LIST OF AMENDMENTS for submission of NMA to LU/205/16/PL
15160 – CAMMELL – LINDEN PARK

GROUND FLOOR PLANS
1:100

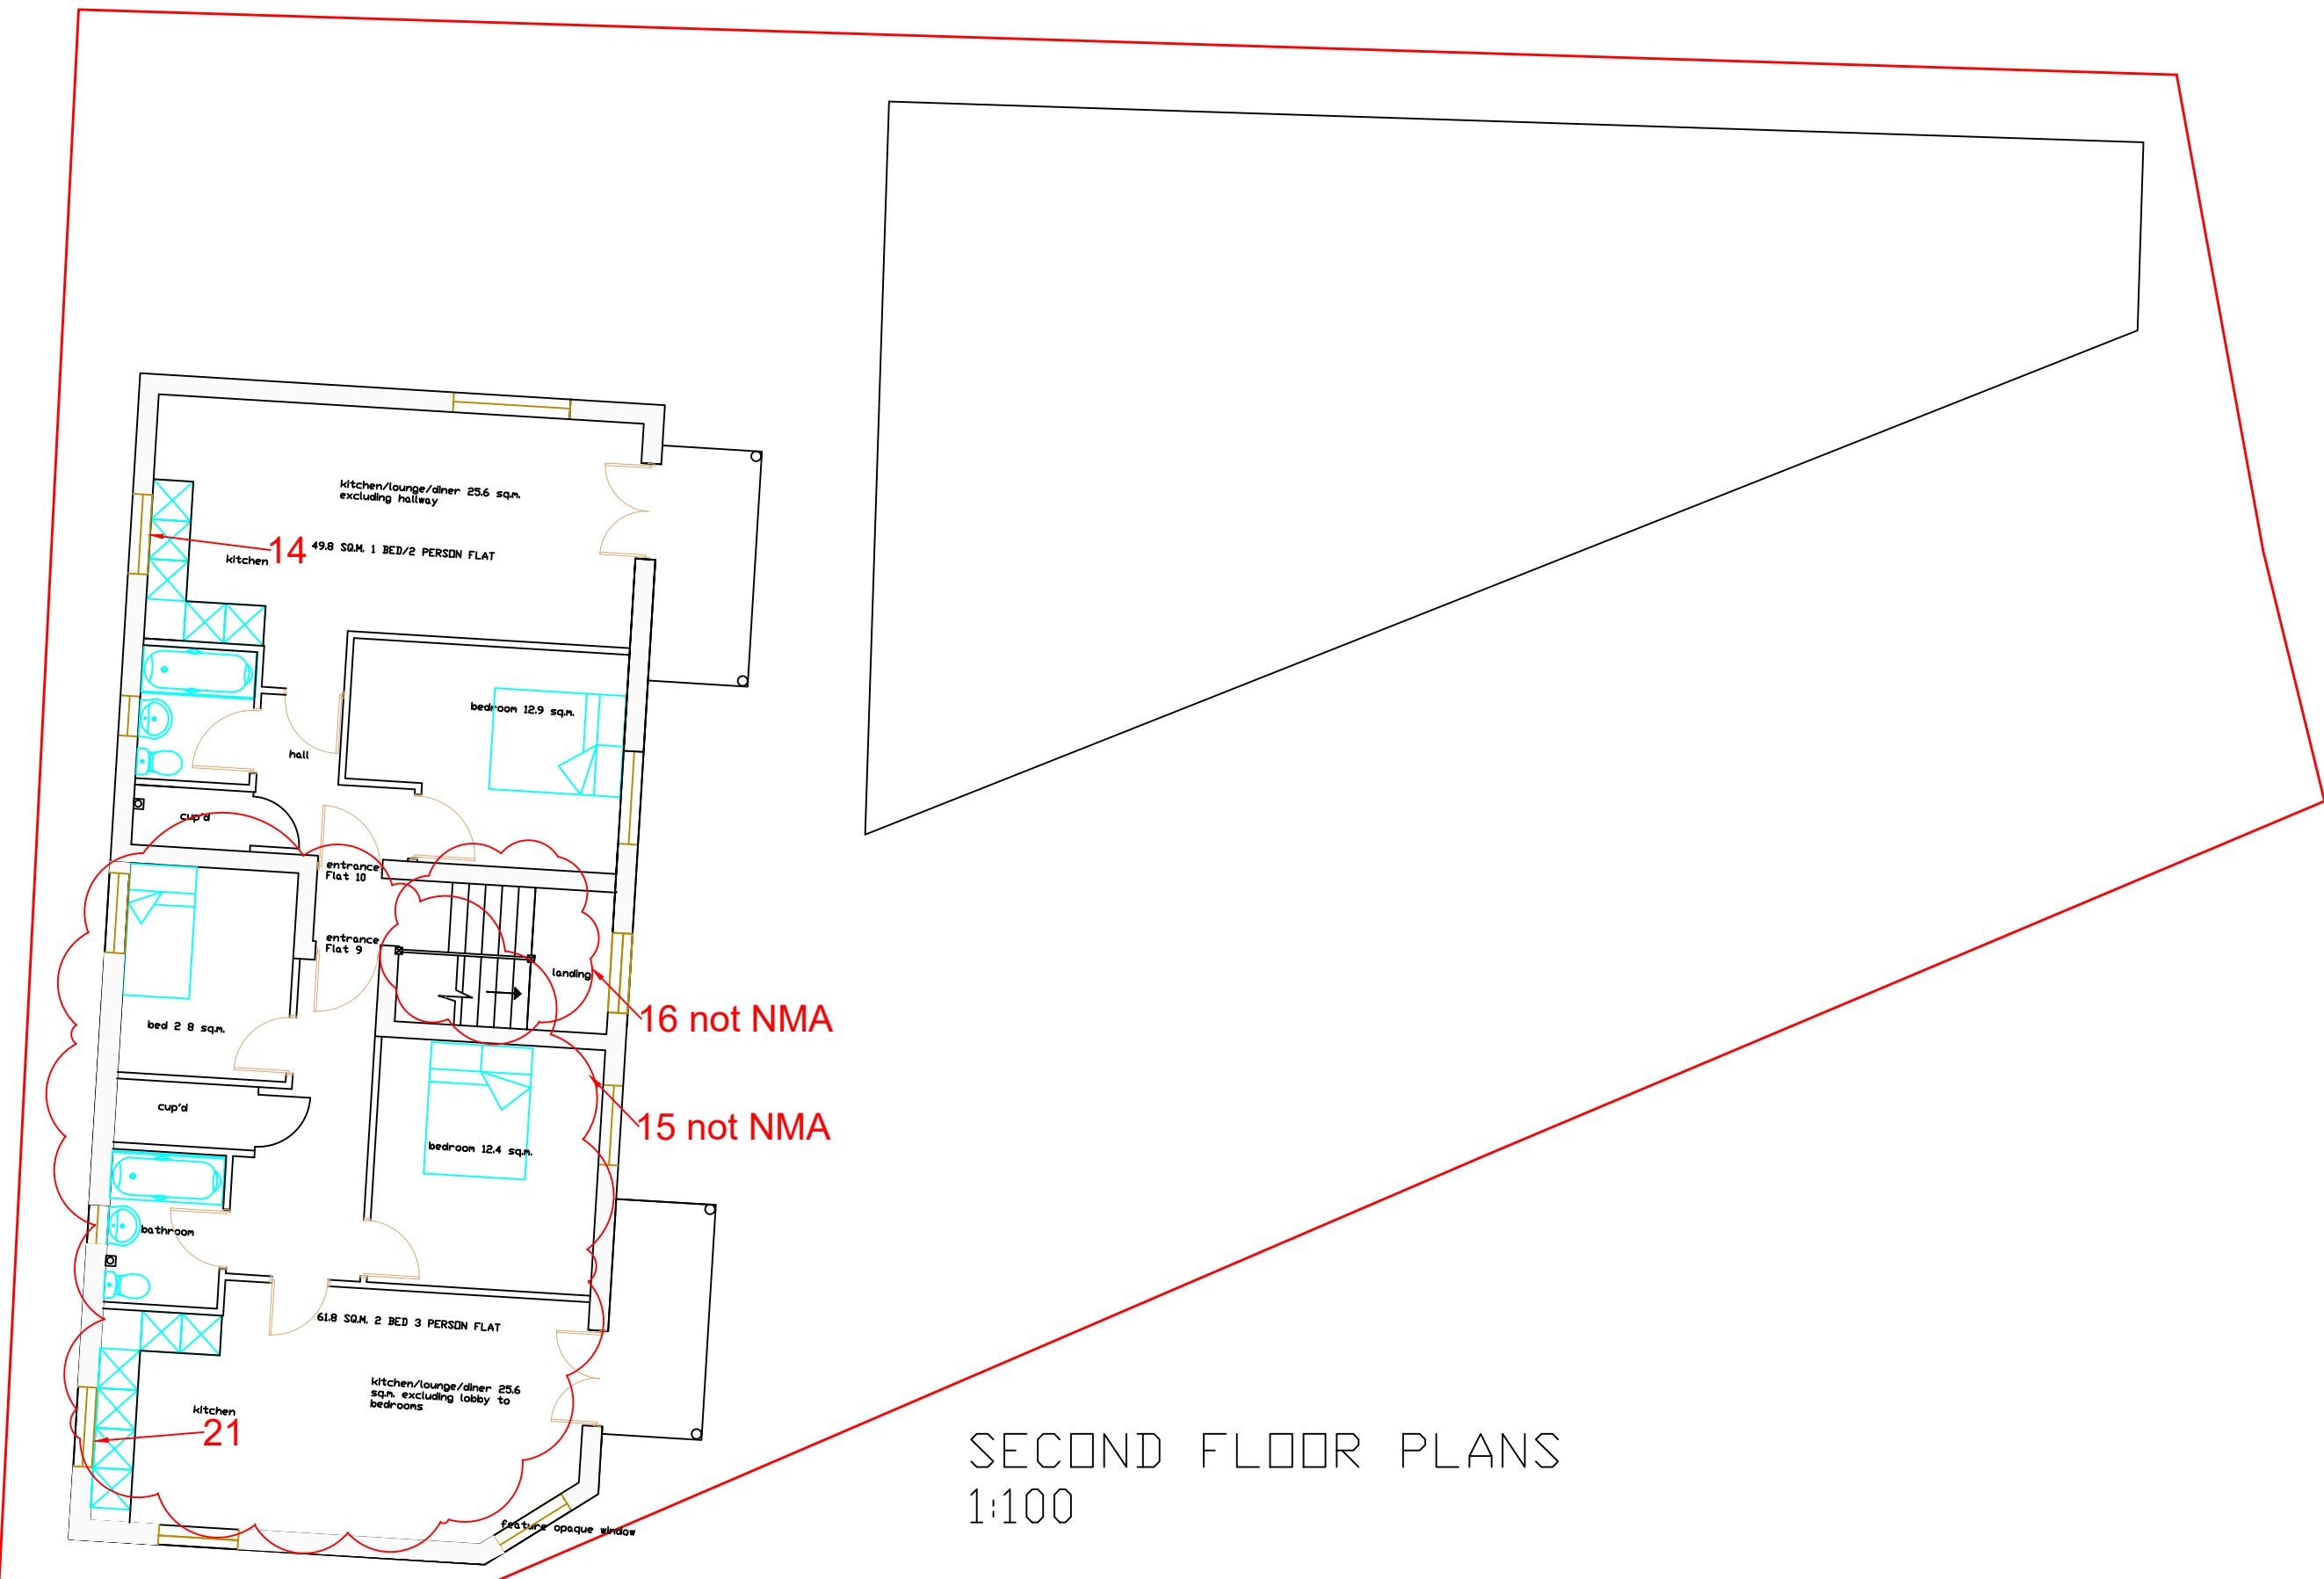
Item	Description	NMA/Info
1	Buildings set at 1010mm from boundary to allow access for scaffold and to negate the need for fire rated glazing on elevations which need to be 1M from the boundary. Buildings also swivelled slightly on site to line up: Block 1 to South Boundary Block 2 to West boundary	Yes NMA
2	Footpath move down and amenity space width reduced slightly to accommodate for moving building forward. Car parking not affected	Yes NMA
3	Flat 1 – Amenity space extended to in front of window	Yes NMA
4	Flat 2 – Amenity space extended and gate added for access	Yes NMA
5	Flat 1 – Entrance to Flat 1 relocated to inside main entrance to facilitate improvements to internal layout. Original front door in South elevation removed.	Yes NMA
6	Flat 1 - High level window now in West elevation. Normal cill window in South elevation`	Yes NMA
7	Flat 3 - High level window now in West elevation. Normal cill window in South elevation`	Yes NMA

8	Flat 3 – Internal changes to line walls up with other floors	Information Only
9	Flat 4 – Internal amends to entrance to provide lobby	Information Only
10	Flat 4 – Kitchen window smaller (800 instead of 1200) and moved over	Yes NMA
11	Flat 2 – Internal entrance blocked off. Entrance now from East elevation and double doors changed to single door with full height side light	Yes NMA
12	Flat 5 – Reconfigured to line more walls up (and bathroom)	Information Only
13	Flat 5 – Window to bedroom 2 moved 250mm	Yes NMA
14	Flats 6, 8, 10 – Window to kitchen area (far West) moved inward to East by 600mm	Yes NMA
15	Flat 9 – reconfigured.	Information Only
16	Stairs from first to second floor in Block 1 reconfigured	Information Only
17	Balconies throughout. Added vertical supports to all outward corners to support reduction in cost of build.	Yes NMA
18	Block 1 (3 storey) Stairwell. FF landing window on ½ landing deleted.	Yes NMA

19	Block 1 FF landing window to South elevation made bigger to match 2 nd floor bedroom window	Yes NMA
20	Flat 5 Bedroom 1 – Small window deleted due to new internal layout	Yes NMA

21	New windows to South elevation to Block 1, flats 5, 7, 9. New windows positioned in kitchen.	Yes NMA
22	Retained walls now shown on Site Plan to North boundary. Originally the walls were to be removed and replaced with fencing. It is now proposed to retain the flint wall to this boundary as well as part of the building wall which is attached to it. It is felt this adds to the security of the site.	Information Only
23	Communal Amenity Space to put bin store more accessible to residents and collection operatives. (perhaps residents more likely to use the bin store correctly if more convenient. Also existing concrete base retained instead of planting grass which may be difficult to maintain in this area.	Yes NMA
24	General Note: Bathrooms sized, where possible, to length of bath, to support reduction in cost of build, Walls moved and reconfiguration to consolidate walls under each other in plan, wherever possible.	Information Only
